**From:** Bruce Hyman  
**To:** Jean Fraser  
**CC:** Barbara Barhydt; David Margolis-Pineo; Errico Thomas; Jeremiah Bartlett  
**Date:** 4/4/2014 11:05 AM  
**Subject:** Re: Crosswalk for Munjoy Heights (Walnut) - DPS Staff Recommendation  
**Attachments:** MunjoyHgts\_WalnutStCrosswalkDPSSStaffRecommend\_Apr04-14.pdf

The consensus among Tom E, Jeremiah and me is for Option #1 with a slight re-alignment of the crosswalk and location of the curb ramp on the west side of Walnut St.

DRAWING NO.
C-10

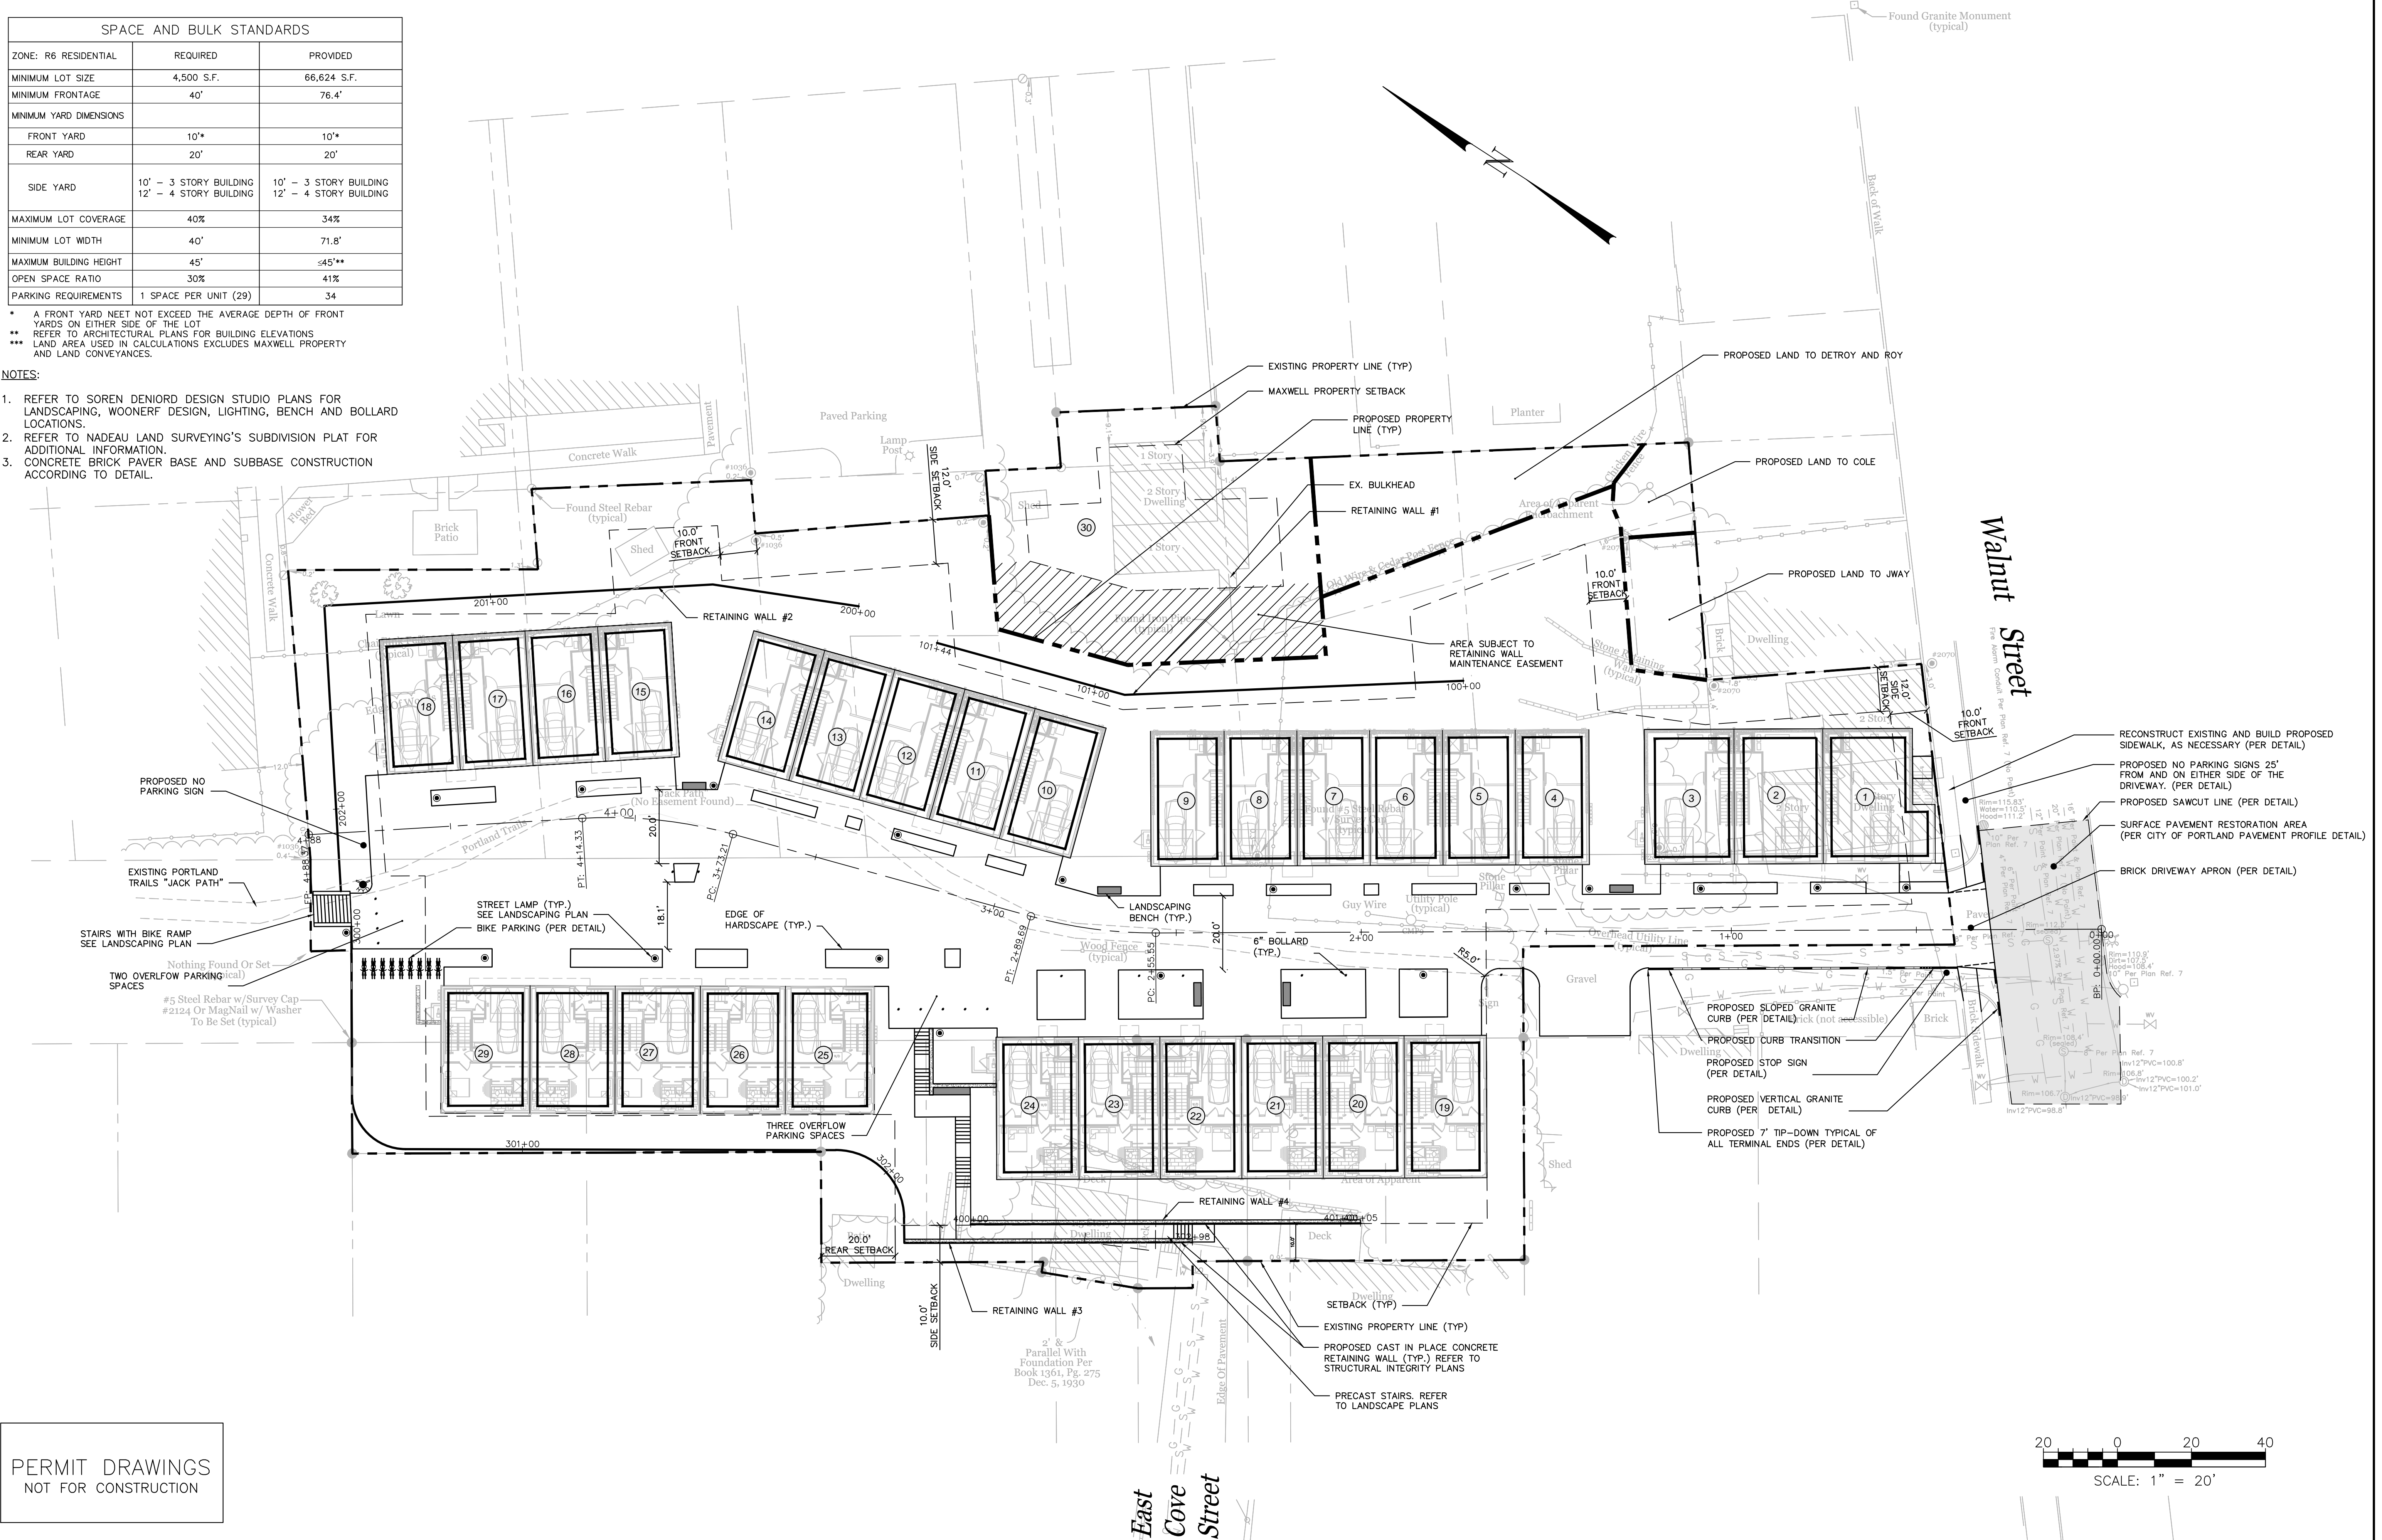
The crosswalk should be oriented/located such that it has at least 4'x4' of landing area within the crosswalk at the base of the ramp at the Sheridan St corner. The crosswalk must also extend the full width of the bottom ramp where it meets the street.

OPTION #1

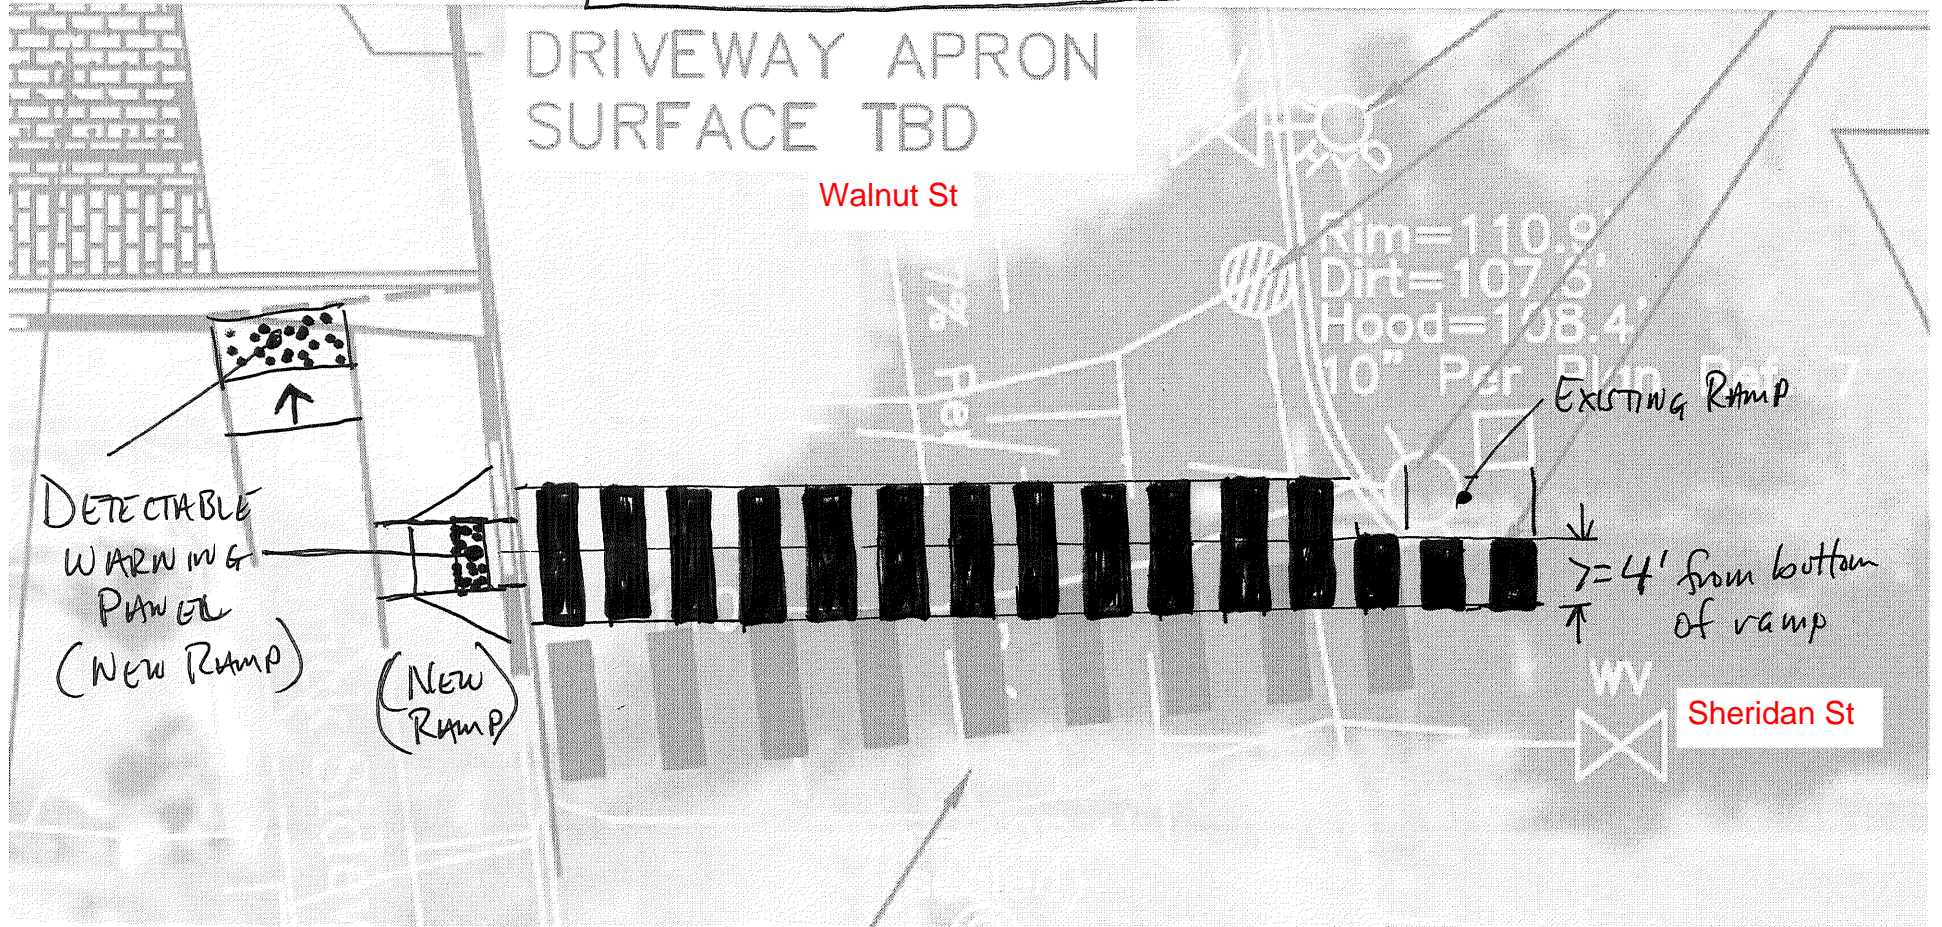
I've attached a quick sketch showing the recommended orientation and location of curb ramps and the crosswalk.
